From: [REDACTED]
Sent: 30 November 2020 17:00
To: Amber Willard
Subject: RE: Application ref: P/108/20/HH - 32 East Front Road, Pagham - Update on progress
Attachments: Measured Proposed Site Plan.pdf
Follow Up Flag: Follow up
Flag Status: Flagged

From: [REDACTED]
Sent: 30 November 2020 15:18
To: [REDACTED]
Cc: [REDACTED]
Subject: Application ref: P/108/20/HH - 32 East Front Road, Pagham - Update on progress

Rev	Revision	Date
PROJECT		
32 East Front Road, Pagham		
TITLE		
Proposed Site Plan		
DRAWING No. P0009	SCALE (@A1) 1 : 50	Project Ref: J20025
THE EMARRA COMPANY		
www.emarra.co.uk Tel: 07803 924465 Email: info@emarra.co.uk

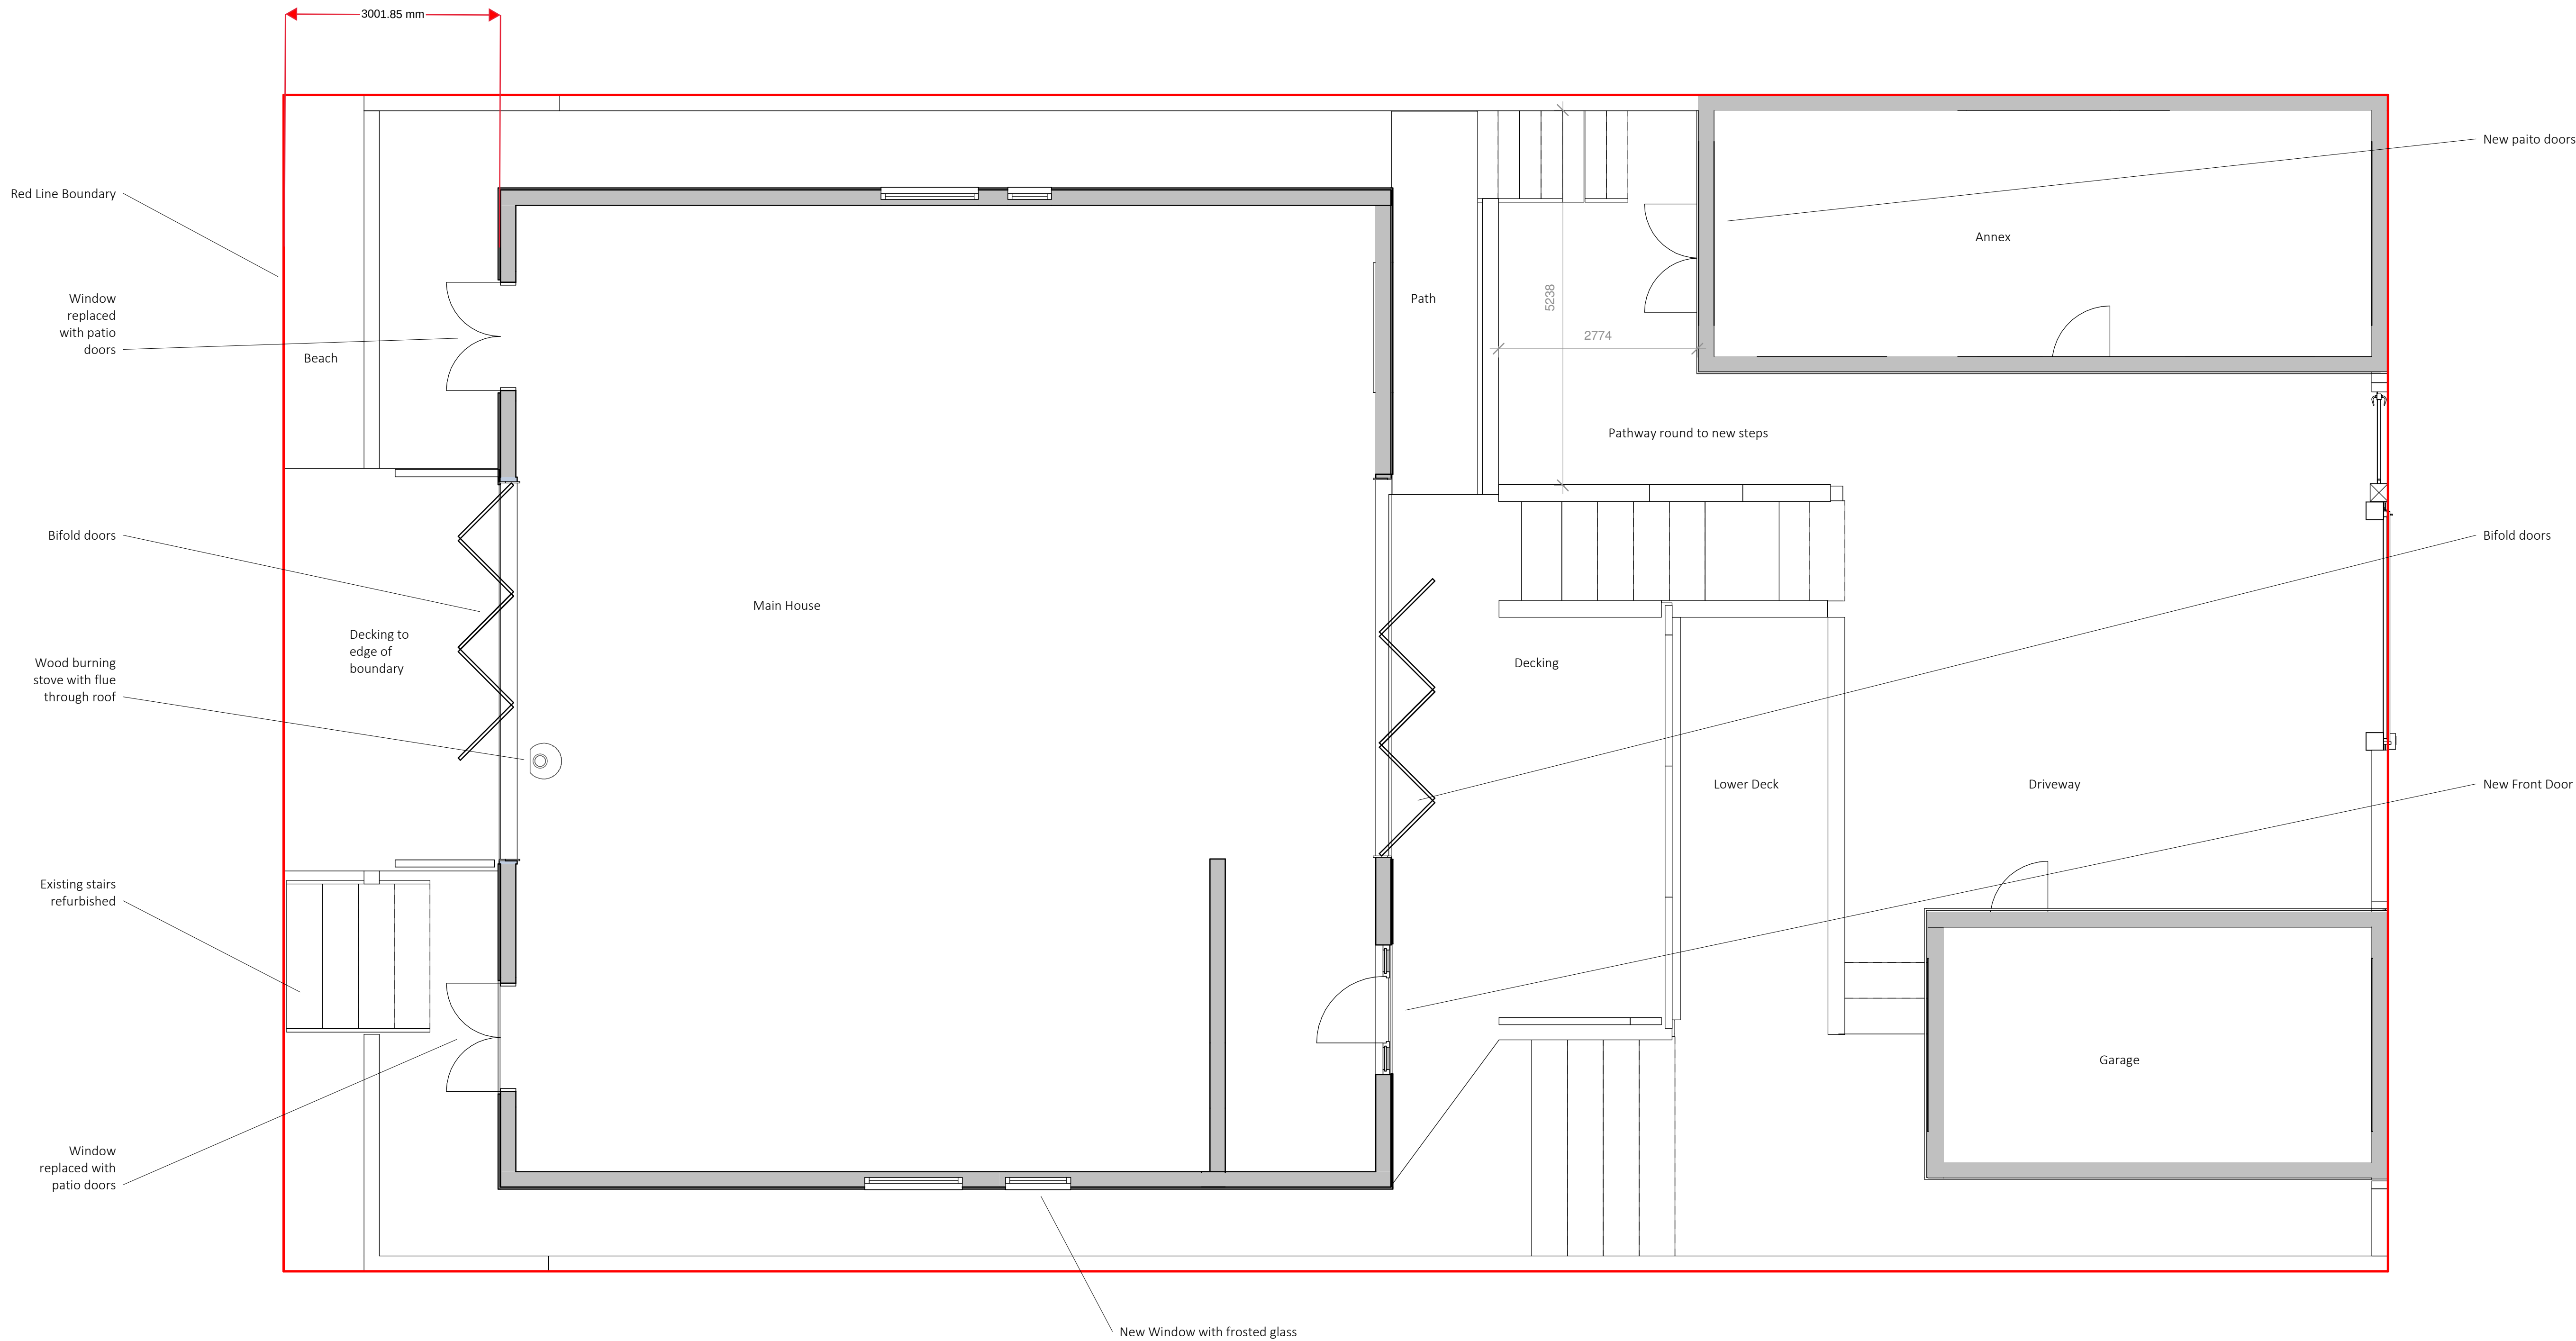
In terms of Pagham Beach Holdings concerns with regards to the P0009 – Proposed Site Plan Drawing: scaling off, this shows 3m from house to red line in accordance with the above.

The fact that the retaining wall is inside the redline does not detract from the ownership. It may be that this is a cosmetic wall and that the retaining beach wall is behind. There are no plans to make any changes to the wall at this time.

With regards to the steps, these are existing and the Proposed Site Plan clearly states that they are to be refurbished:

With regards to the "removal of a section of the retaining wall and the installation of decking to encroach onto the foreshore", the deck will oversail the retaining wall and will be within the red line boundary. There are no propose changes in level to the foreshore.
